**Consultation Response from KC,
Trees**

2026/92707 Land off, Primrose Lane, Hightown, Liversedge, WF15

Discharge of details reserved by conditions 3 (Arboricultural Impact Assessment) and 10 (Arboricultural Method Statement) on previous permission 2023/91116 for erection of 77 dwellings, with access from Darley Road and associated works

Date Responded: 29/09/2026

Appendix 6: Tree Constraints Plan

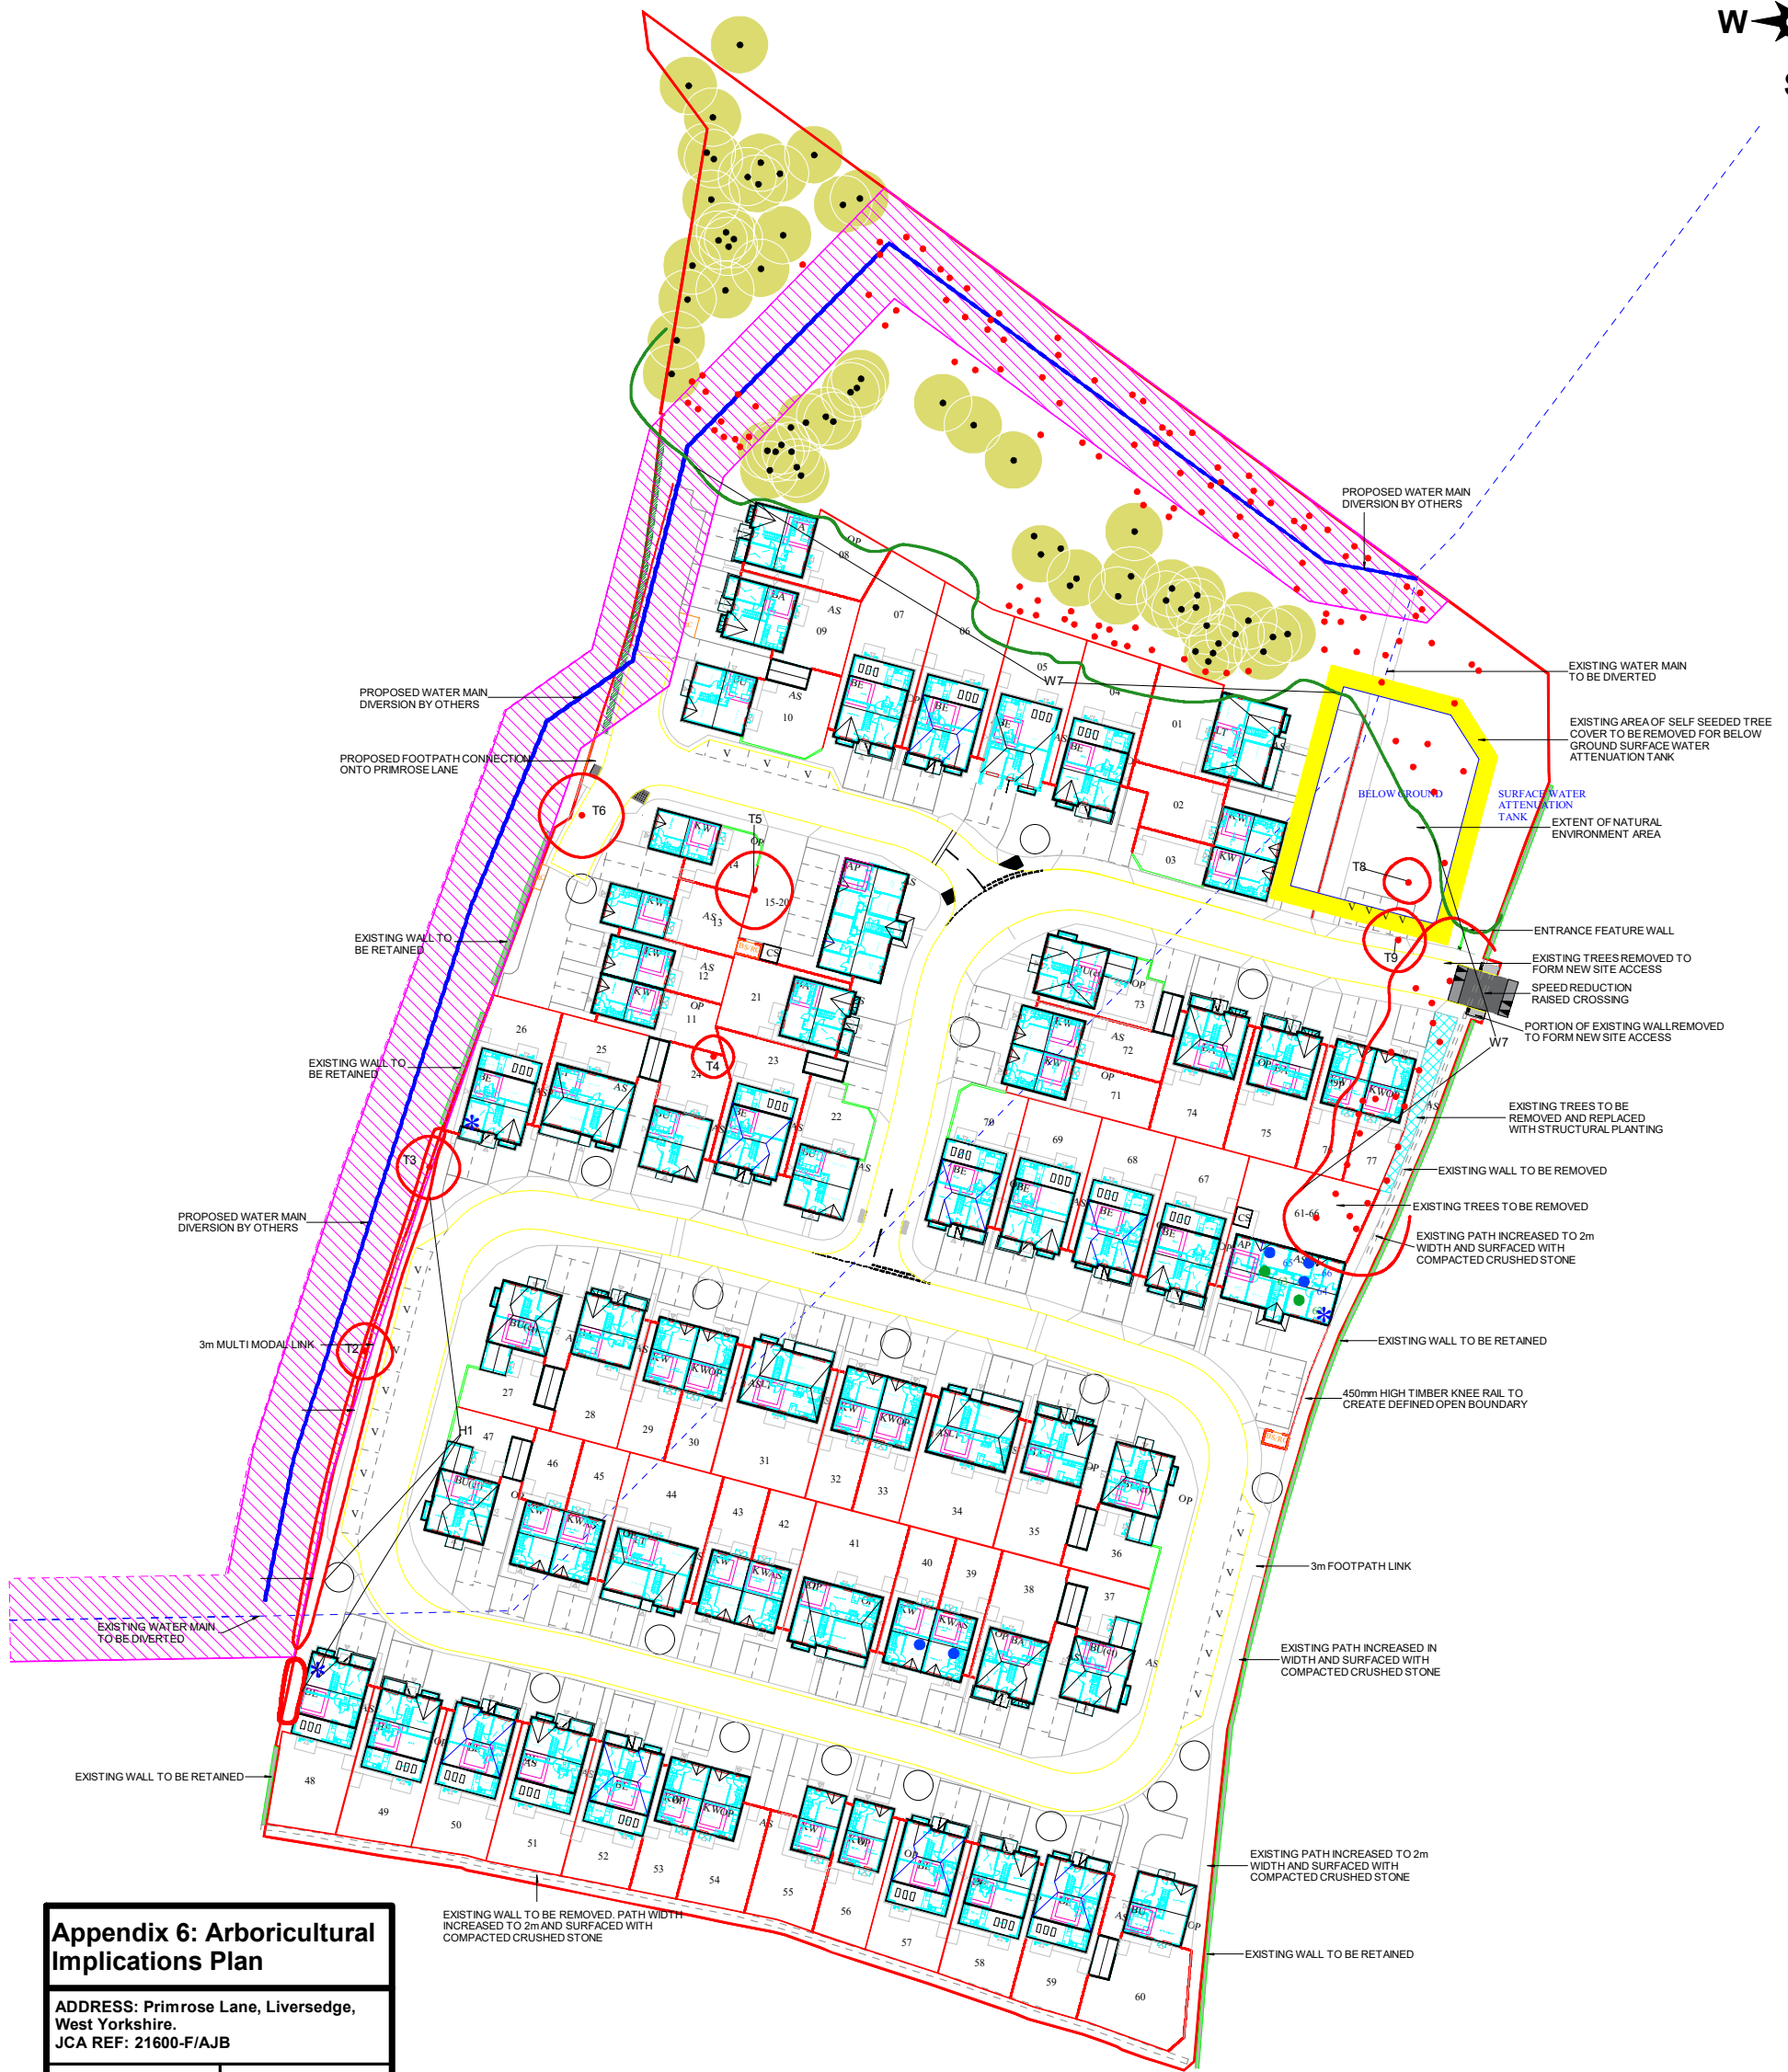
It is suggested that 30 extra trees need to be removed from W7, some which border the gardens of plots 01, 04, 05 and 06, the others are situated to the south of the already approved buffer zone for the water main.

There is no justification relating to why these additional trees need to be removed when there is already substantial loss of trees on the site.

KC trees objects to the discharge of condition 3 due to unjustifiable tree removal which is in conflict with LP33 and LP24(i).
